AA/SM/MR
17101
8 September 2017

**SECTION 96(1A) MODIFICATION APPLICATION - SSD 6513
BUILDING R1, BARANGAROO SOUTH**

On behalf of Lendlease (Millers Point) Pty Ltd, we hereby submit an application pursuant to Section 96(1A) of the *Environmental Planning and Assessment Act 1979* ('EP&A Act') to modify State Significant Development Application ('SSDA') SSD 6513 relating to Building R1, Barangaroo South ('the site').

The modification (Modification 3) seeks changes to the ground floor outdoor dining area in response to design development and liquor licensing requirements, and the introduction of integrated signage zones within the revised ground floor design. These amendments do not impact on the built form, scale or aesthetics of the development and will not affect access from the public domain. The development, as proposed to be modified, will remain substantially the same as approved.

BR1-ASK-12-00-22

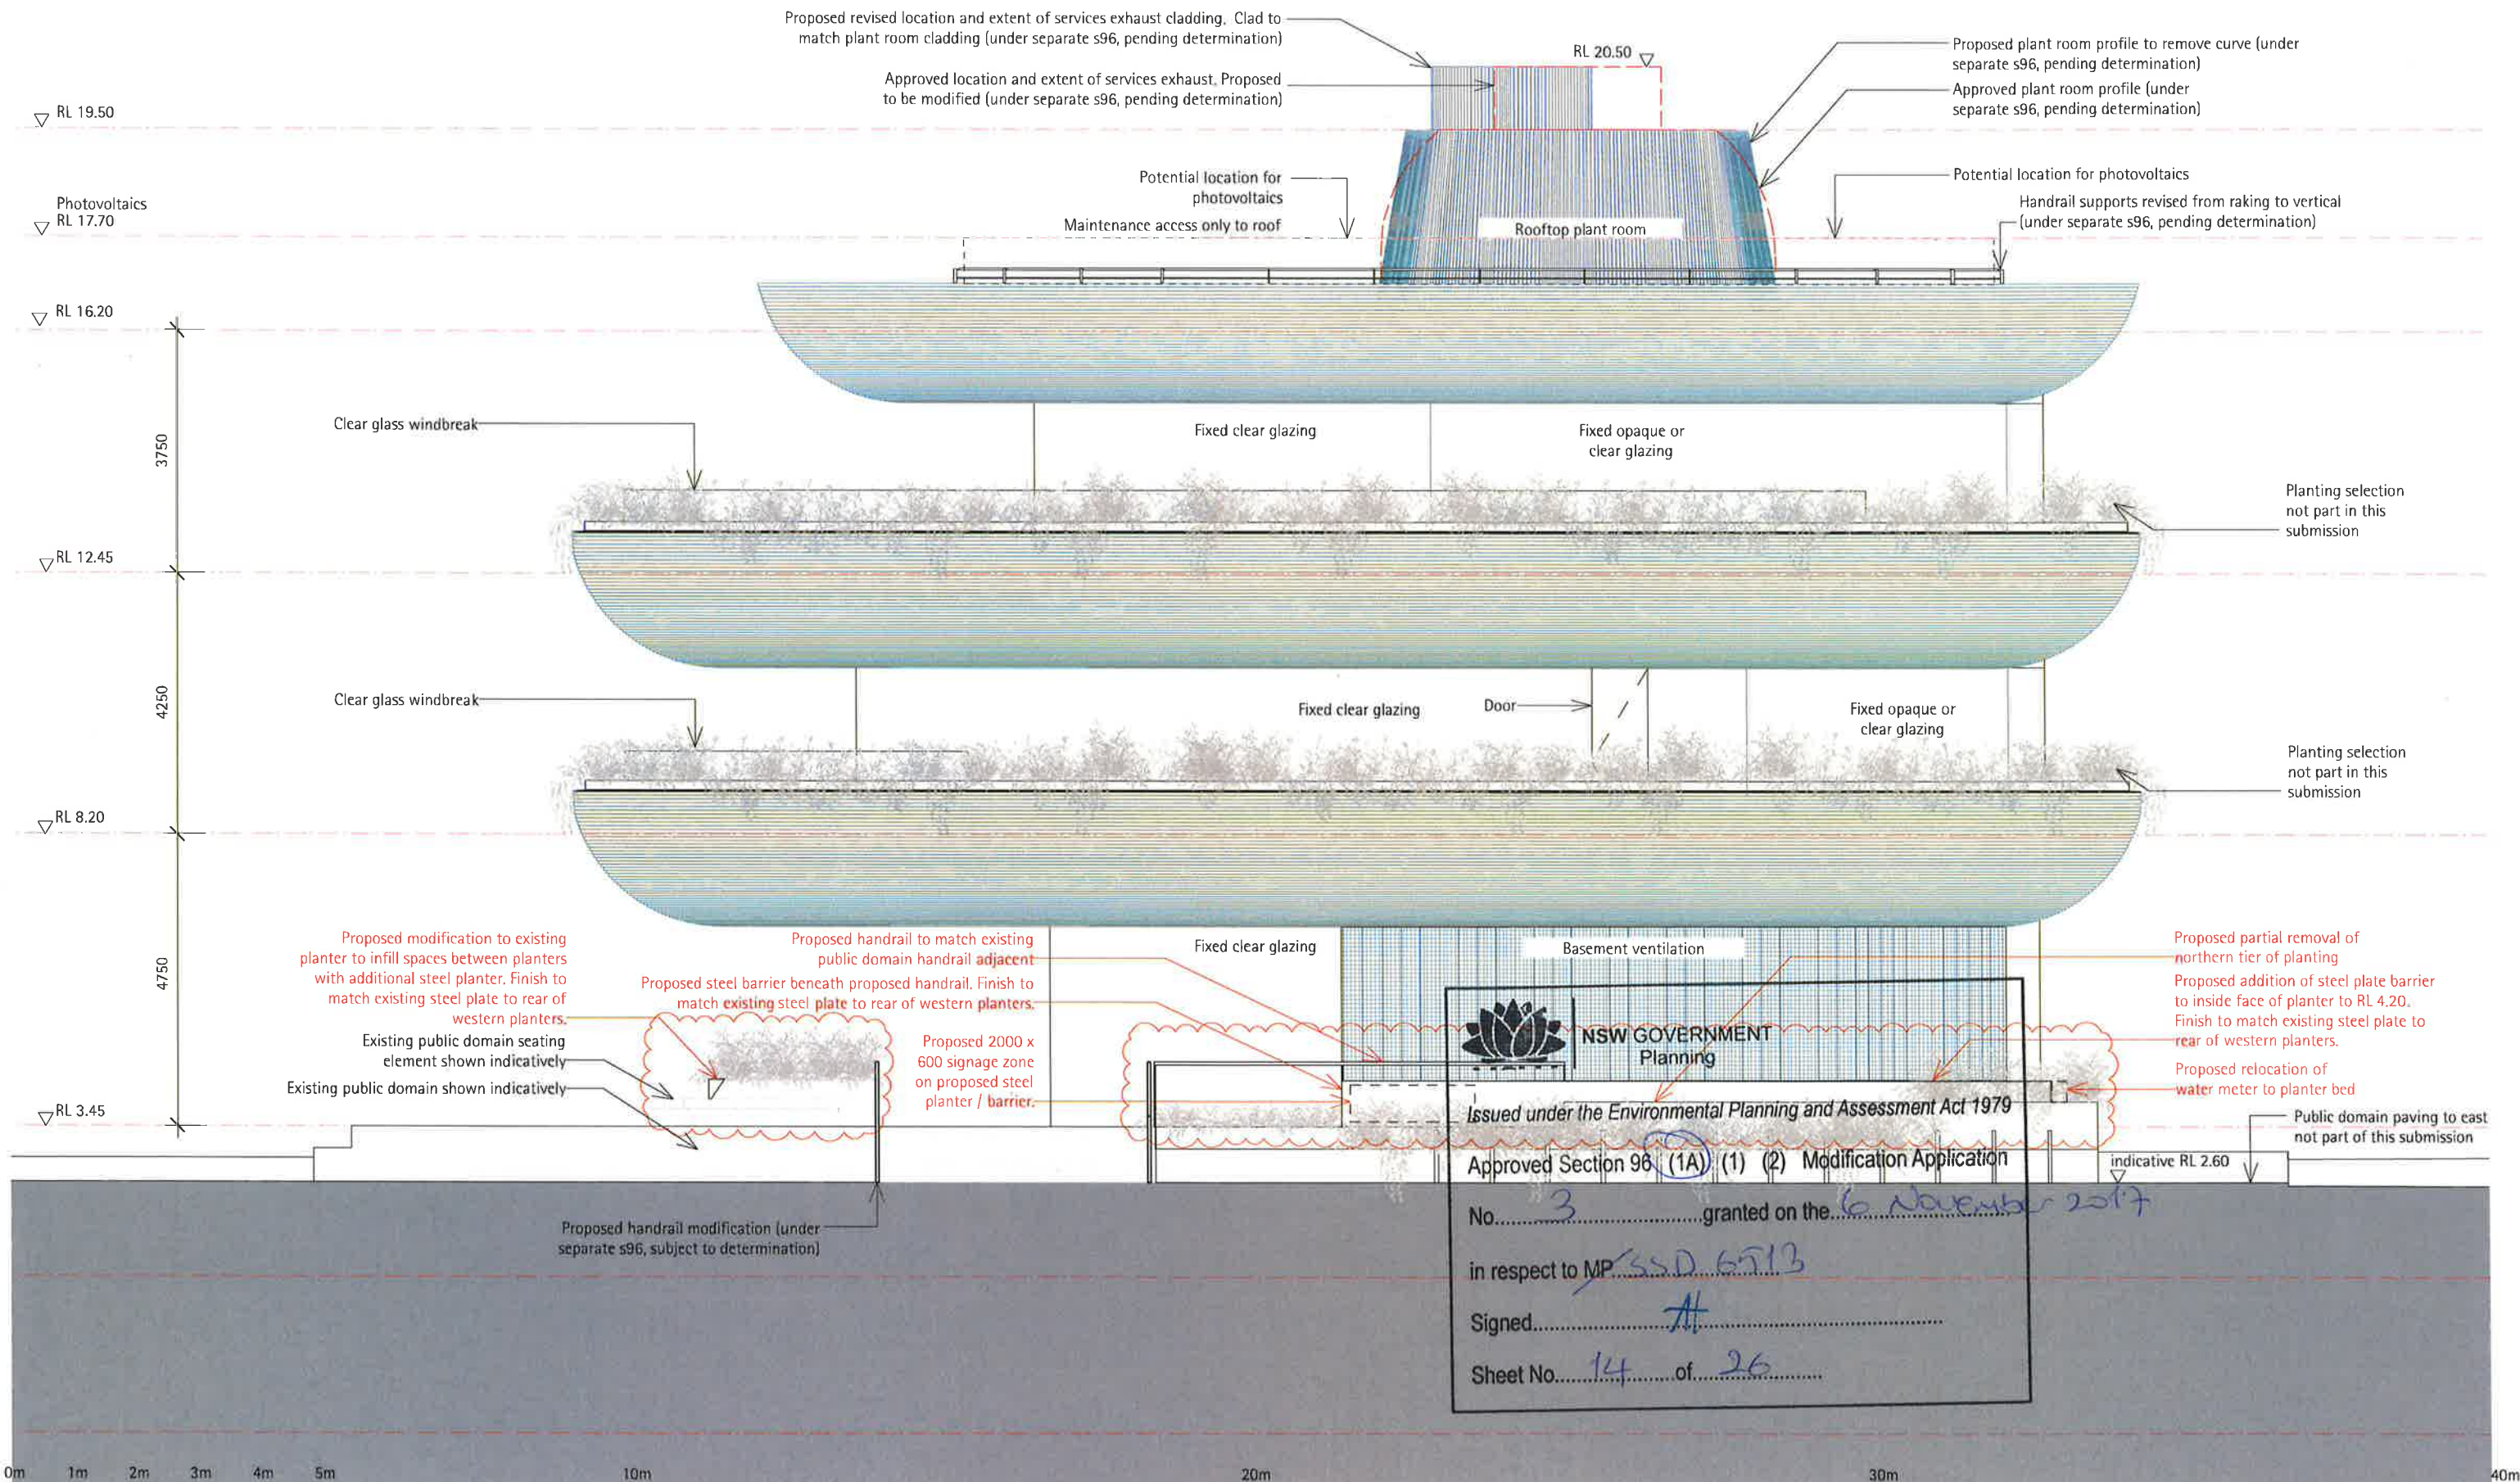
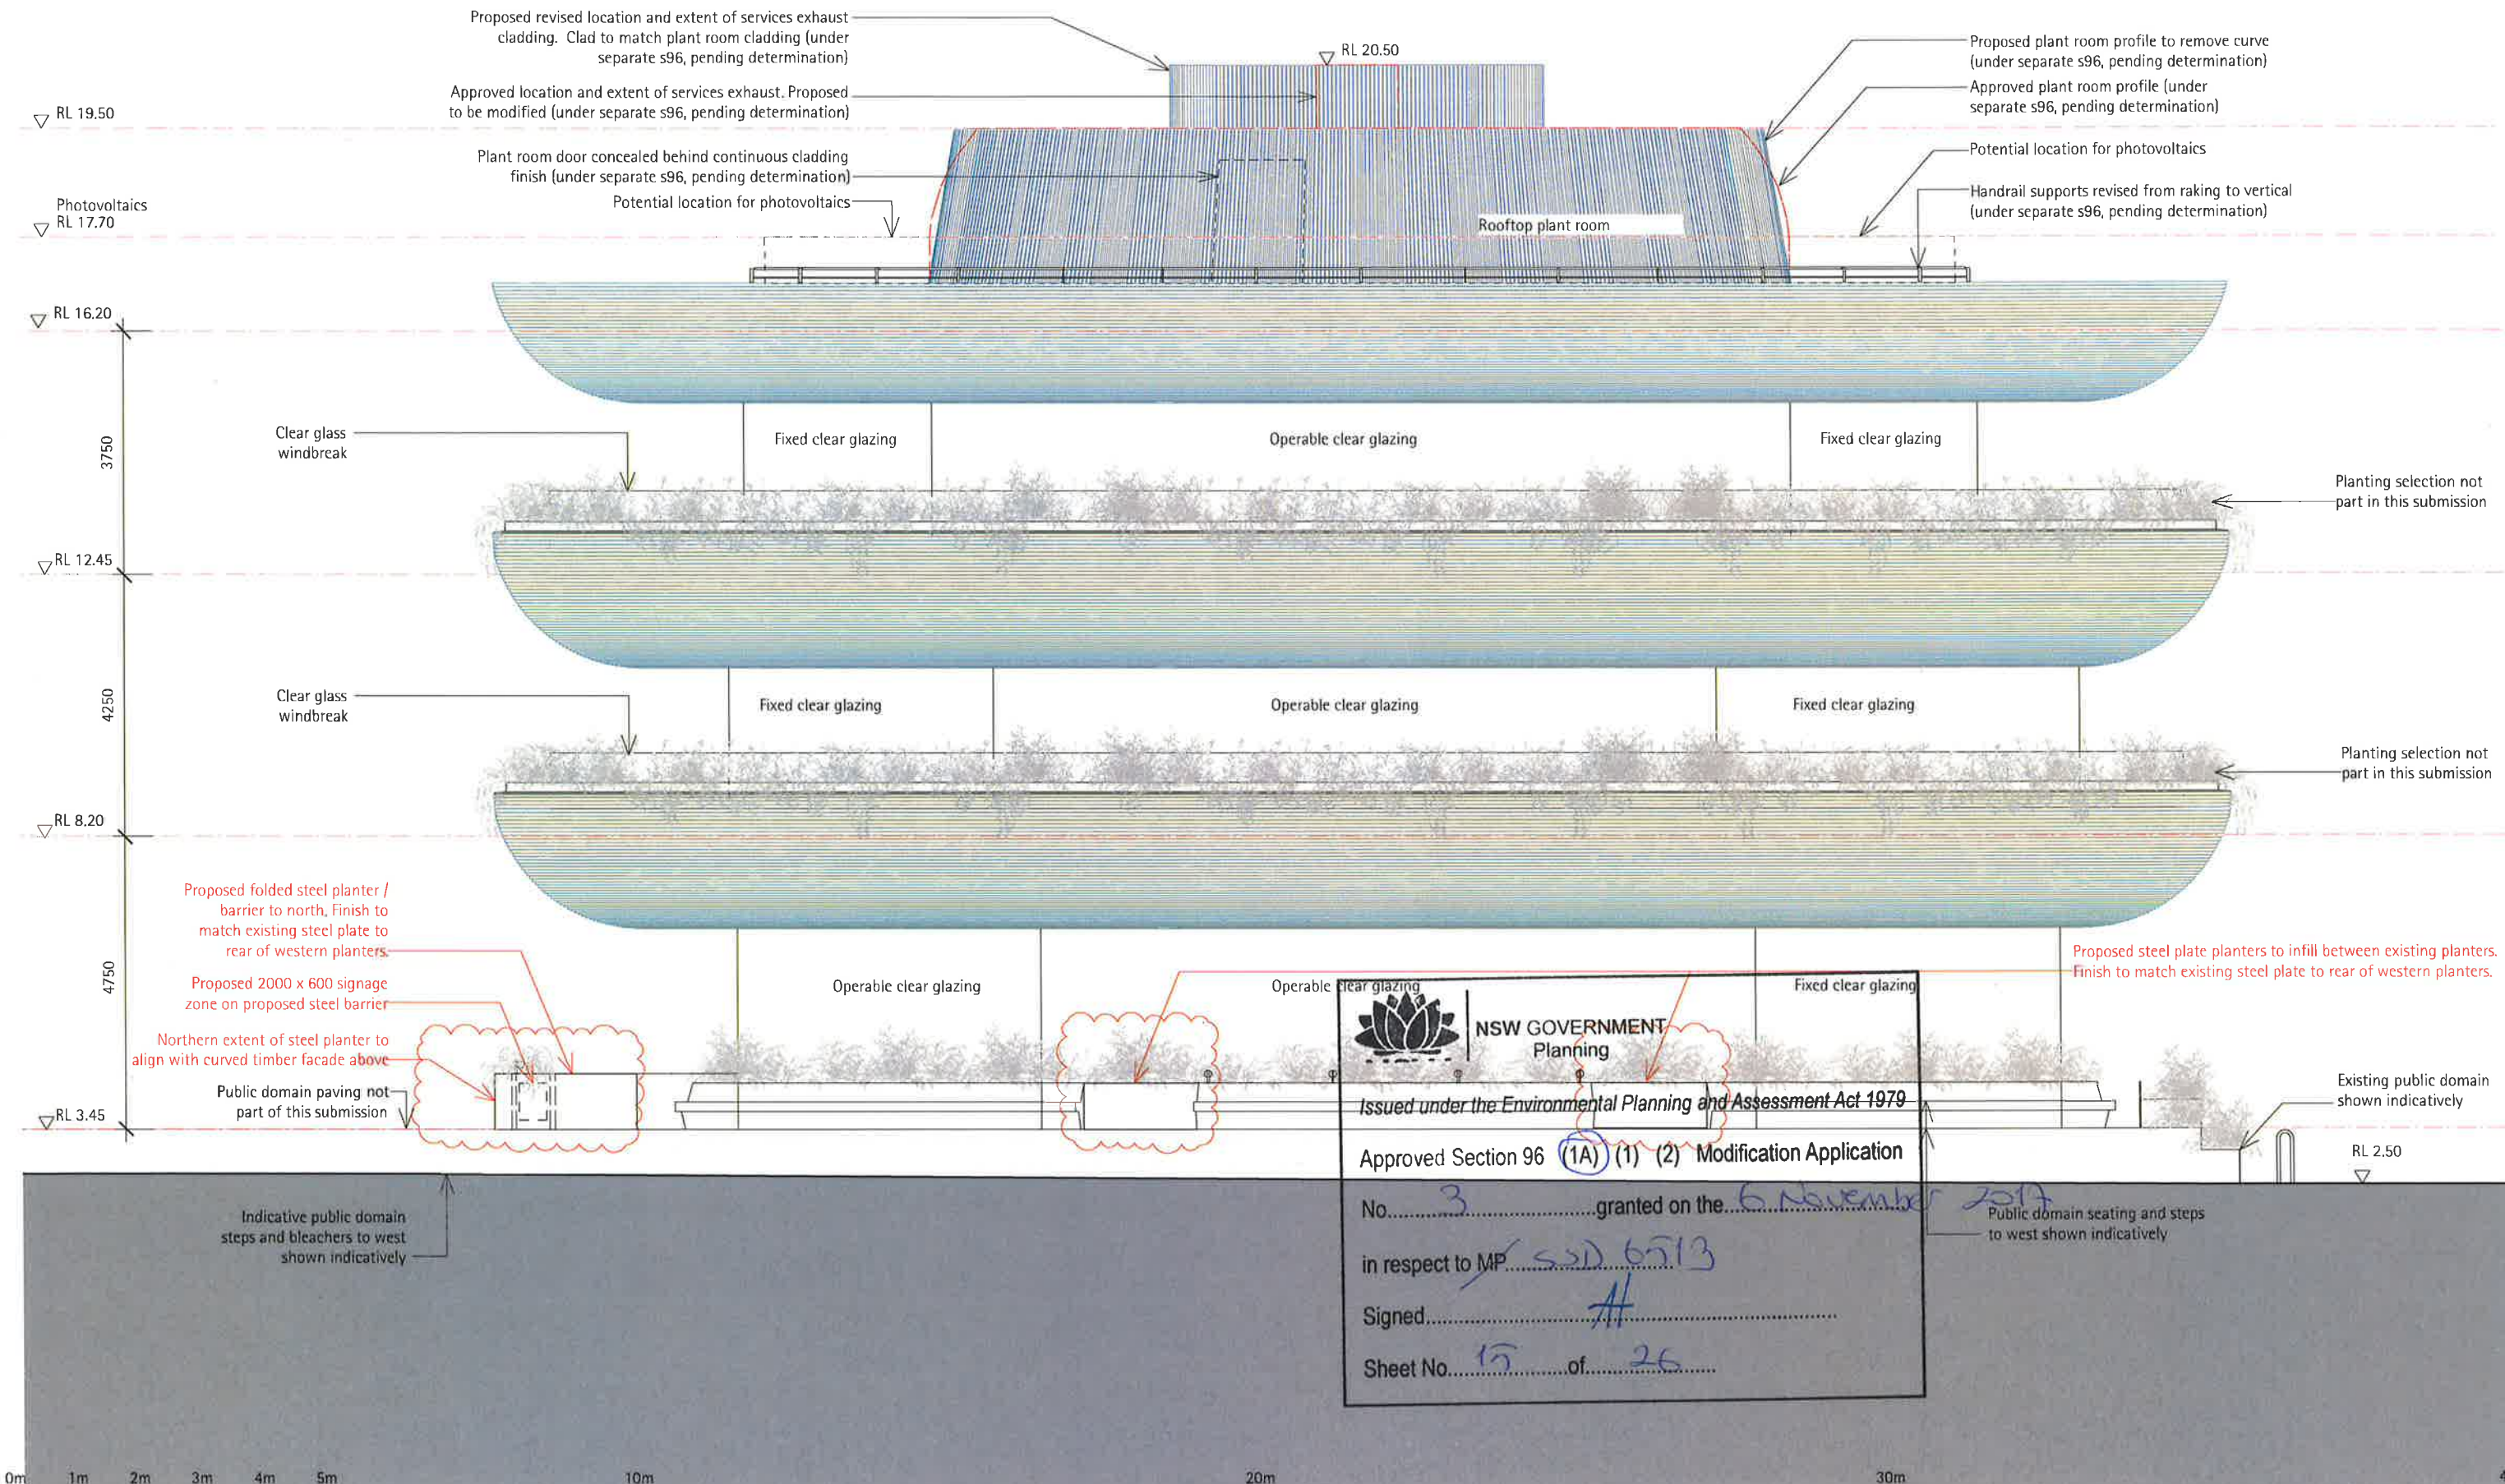
- A signage zone with dimensions of 2000mm x 600mm is proposed on the exterior of the steel planter box on the northern façade adjacent to the entry door;
- A signage zone with dimensions of 2000mm x 600mm is proposed on the exterior of the steel planter box on the southern façade; and
- A signage zone with dimensions of 2000mm x 600mm is proposed on the exterior of the steel planter box on the western façade.

- Alteration of ground floor handrails to match existing public domain handrails;
- Change of operable to fixed window glazing for the northern façade;
- The relocation of the water metre to the eastern garden bed;
- Revised external table lighting and seating configuration; and
- Redistribution of external ground floor seating, including provision of an additional zone on the south eastern corner of the building.
